Application no: 16/00041/DISC-3

**Proposal:** | Discharge of conditions 13 (landscaping), 17 (lighting), 20 (means of access), 22 (parking), 23 (travel information), 24 (archaeological scheme), 25 (archaeological evaluation), 26 (drainage) and 27 (water supply) of 14/01737OUT

**Location:** The Paddocks, The Hale, Chesterton

## Transport

**Table 1: Summary of infiltration testing programme**

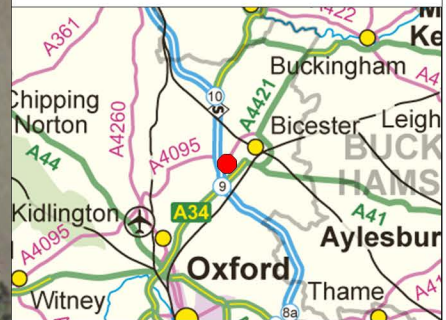
Table 1 identifies soakage tests having been carried out in five trial pits TP 9,10,11,12 and 13. Figure 2 shows that the distribution of the test pits are particularly skewed to the north eastern side of the site. Accordingly, the positioning of the soakage pits does not demonstrate a fair representation of the potential for SUDS infiltration across the whole site. To appraise potential an even spread of tests is required to be carried out by the developer across the total site, unless access is not available and SUDS is clearly not an option.

It is considered that all the soakage test results in the factual report do not rule out the potential for infiltration techniques at any of the locations tested, as all meet the minimum OCC standard for infiltration rates to be not lower than  $1 \times 10^{-6}$  m/s. Please explain why limited use has been made of infiltration techniques at the site, wholly confined to the south-east part of the site. Please advise and confirm.
